Re: Objection to MP08_0244 MOD 1 Modification Request for Mixed Used Development at 23-37 Lindfield Avenue and 11 Havilah Lane, Lindfield

As a resident of Lindfield, I/we wish to lodge an objection against the proposed Modification of the subject development based on the following grounds:

1 SHADOW DIAGRAM - 21stDEC_9AM
5003 SCALE1 : 650

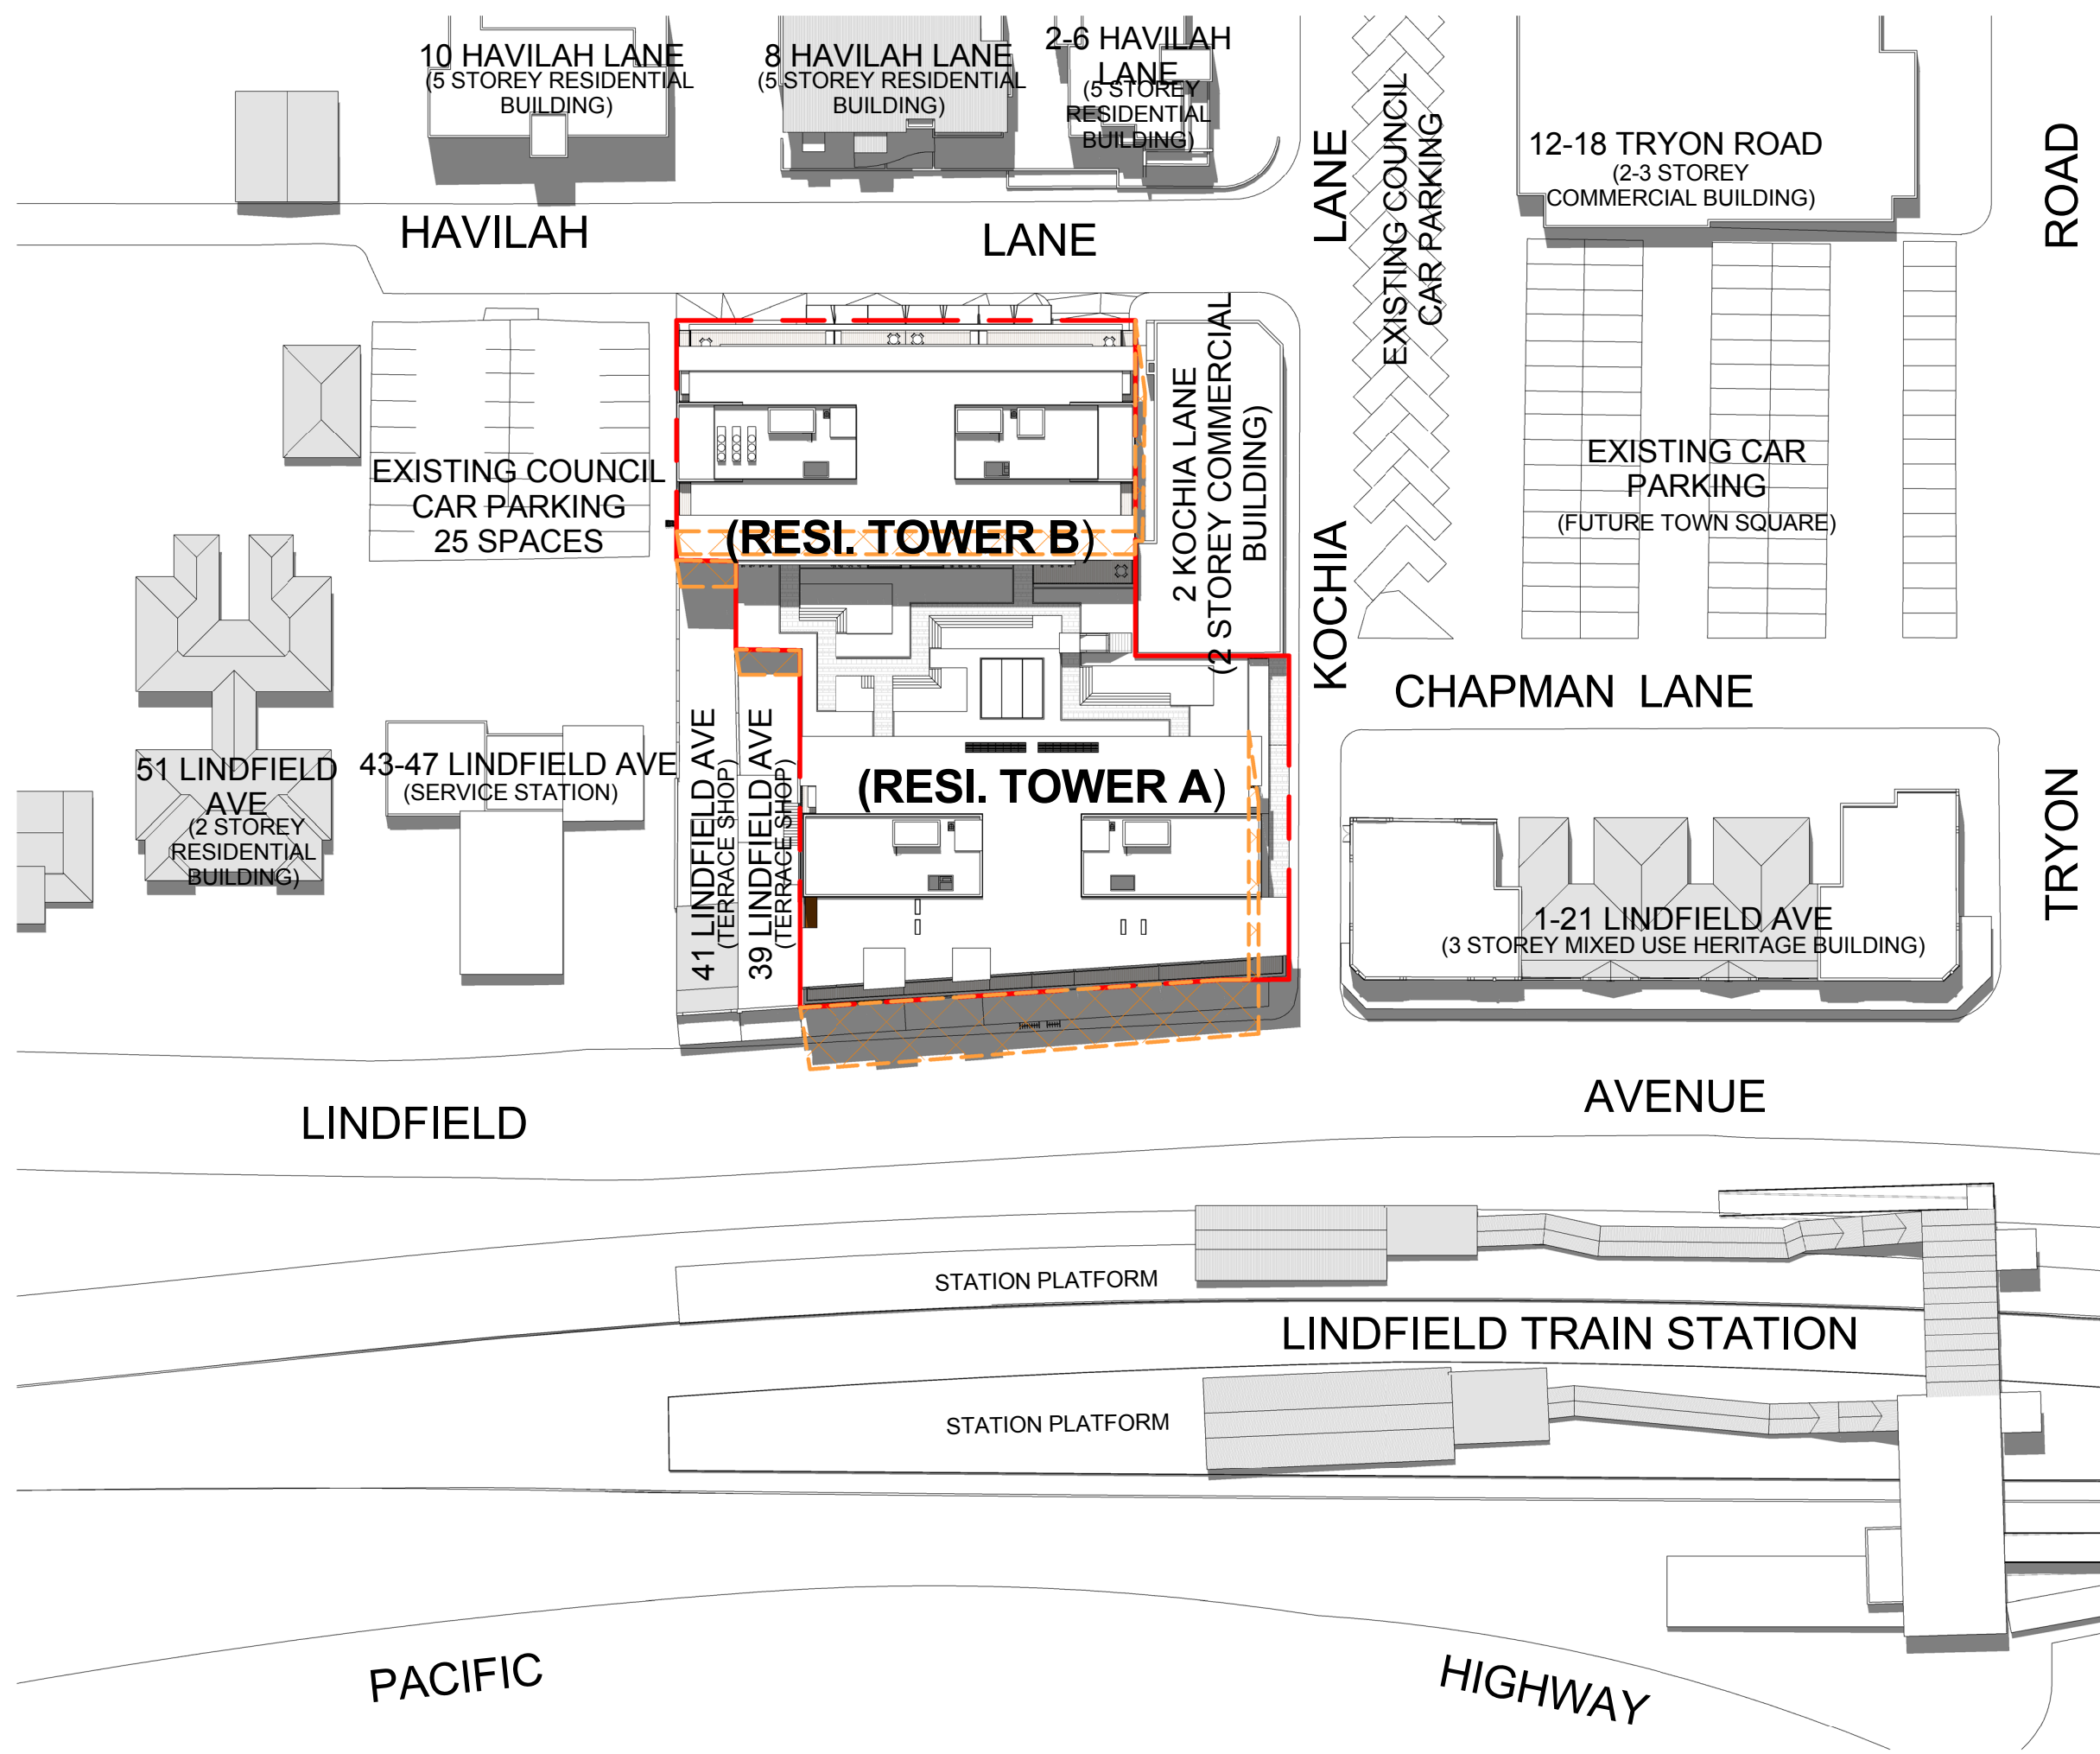
- The additional storeys create additional shadowing: particularly after 3pm for residents in the Havilah Lane apartments, and for all commuters on the city bound Lindfield rail platform, instead of 50% of the year, it will now be 75% of the year in the mornings.
